Awel y Môr Offshore Wind Farm

Application Errata List

Date: 24 October 2022

Revision: A

FIGURE NUMBER:
Figure 19

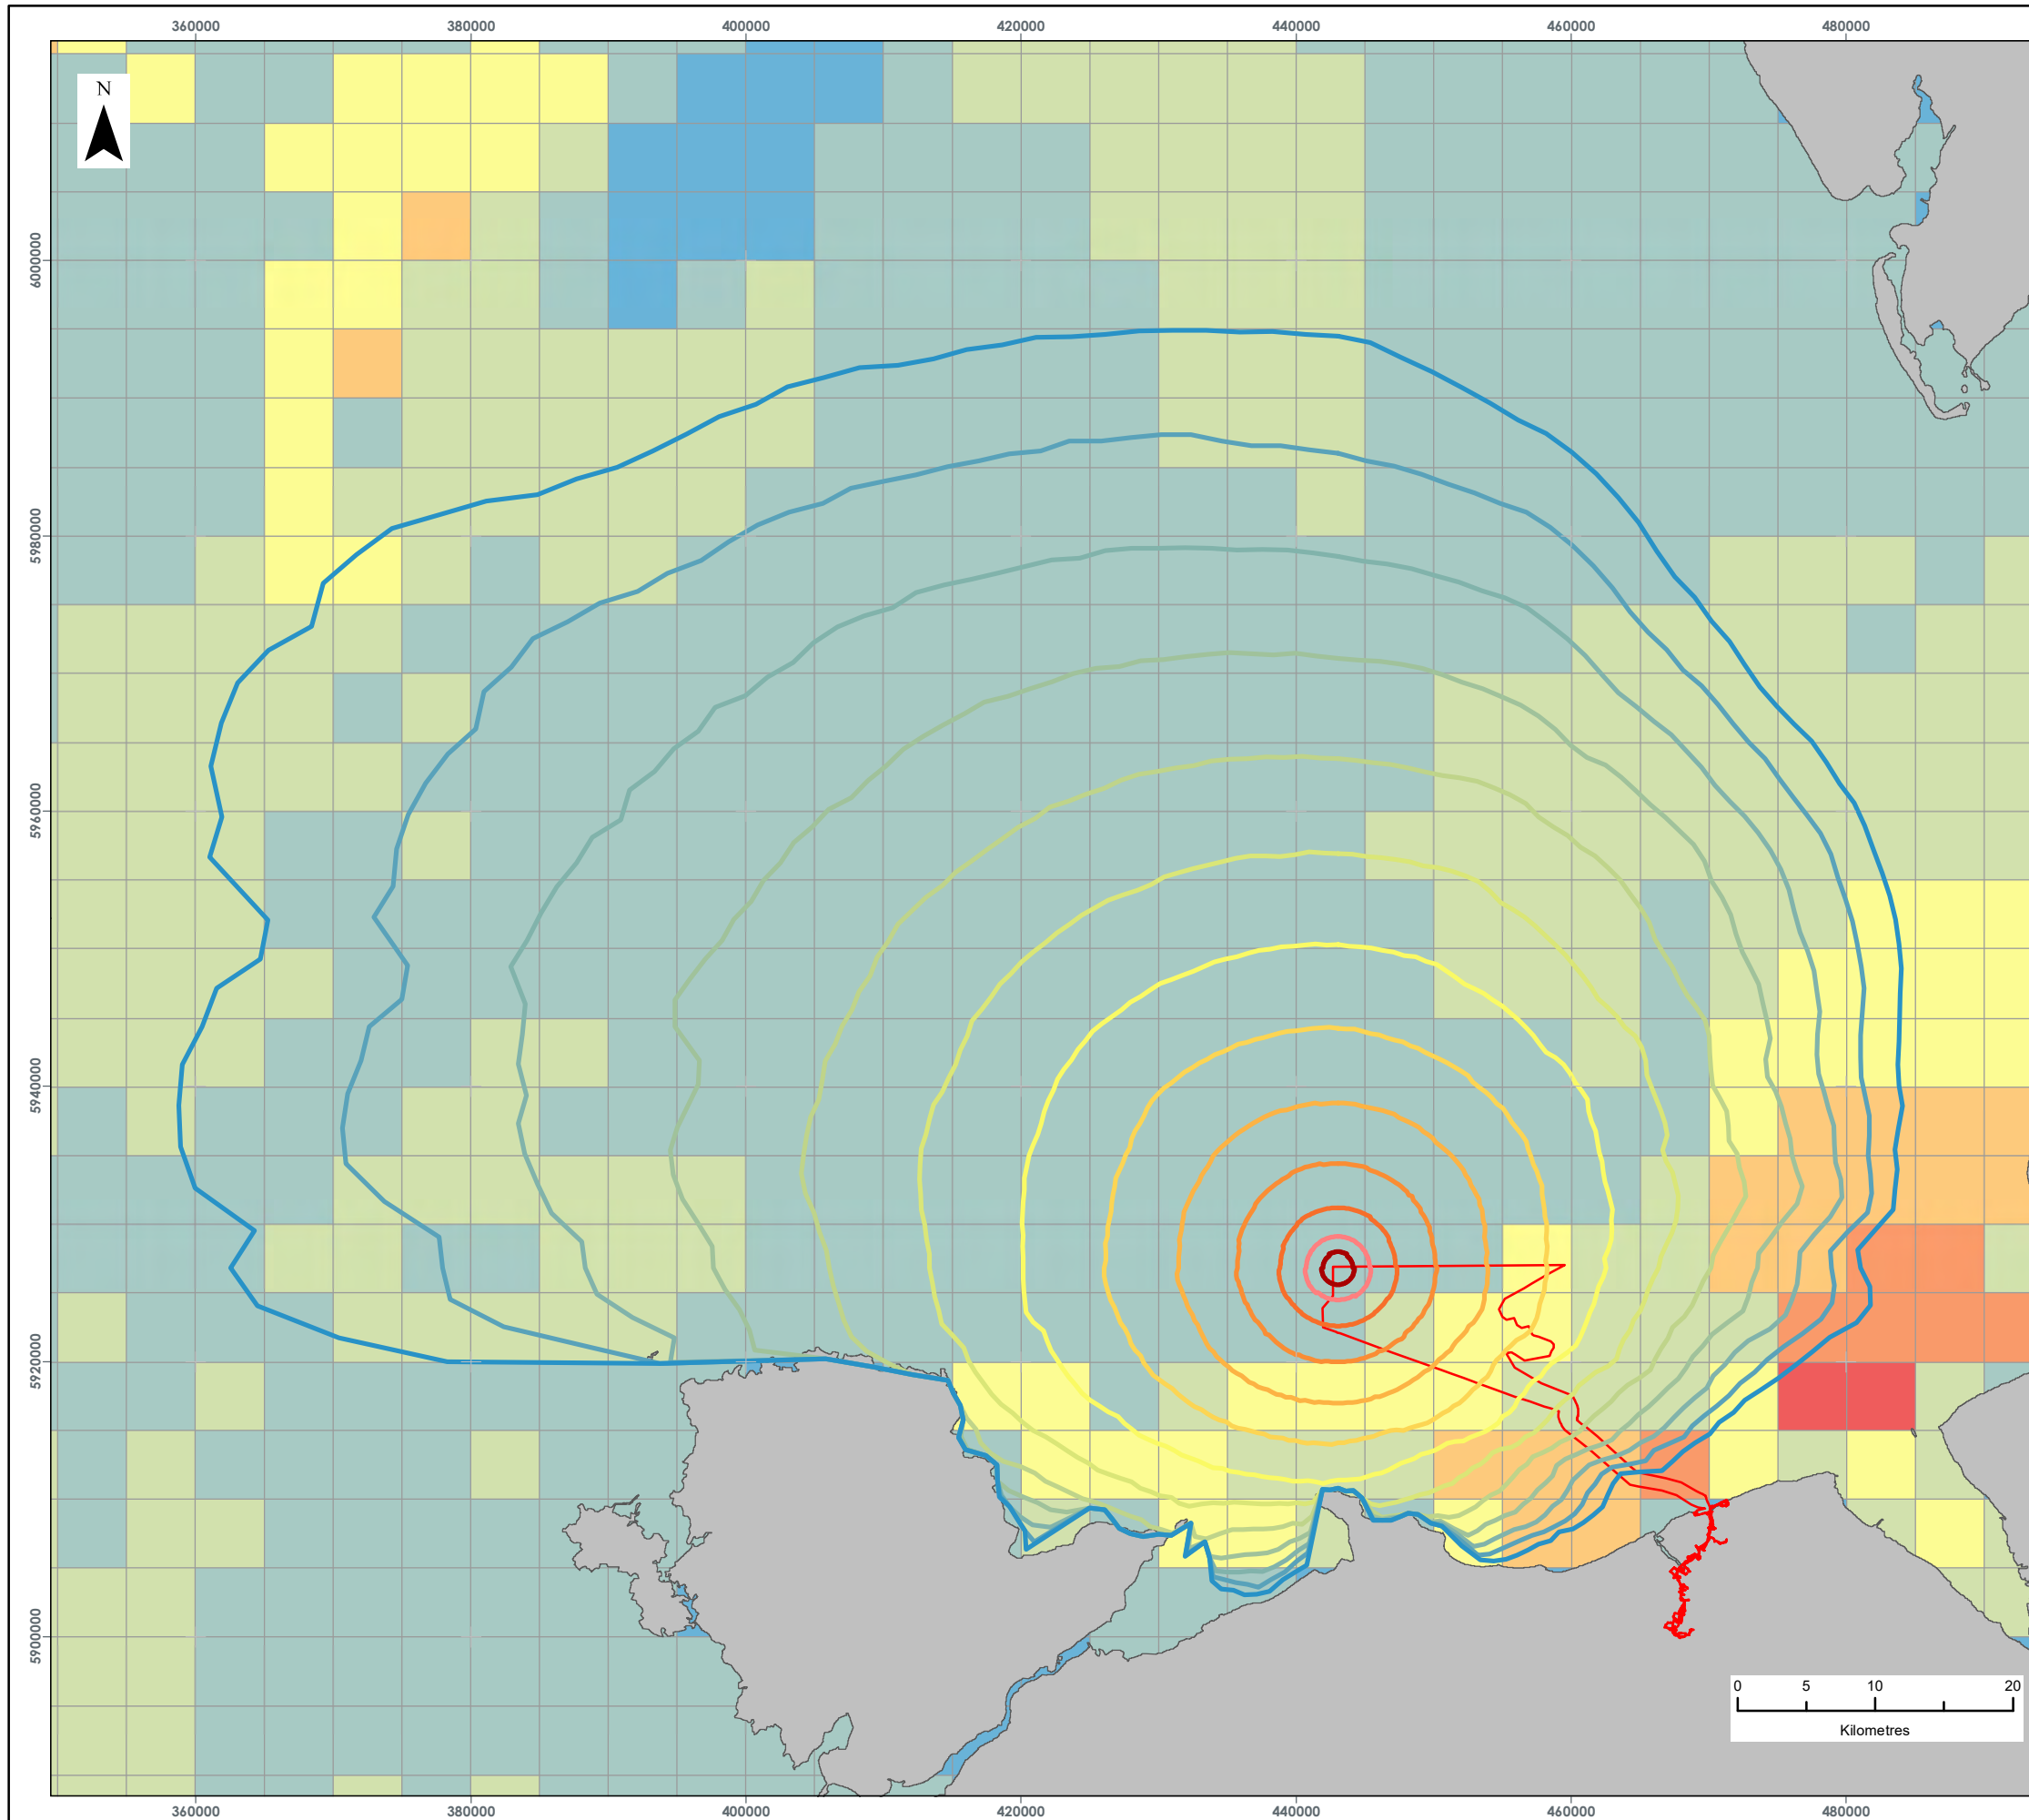
- ▲ Figure 19: Figure missing from AS-026 with Figure 21 incorrectly presented in its place. Corrected figure provided in Appendix A of this document. Note this figure is identical to Figure 19 presented in APP-053.
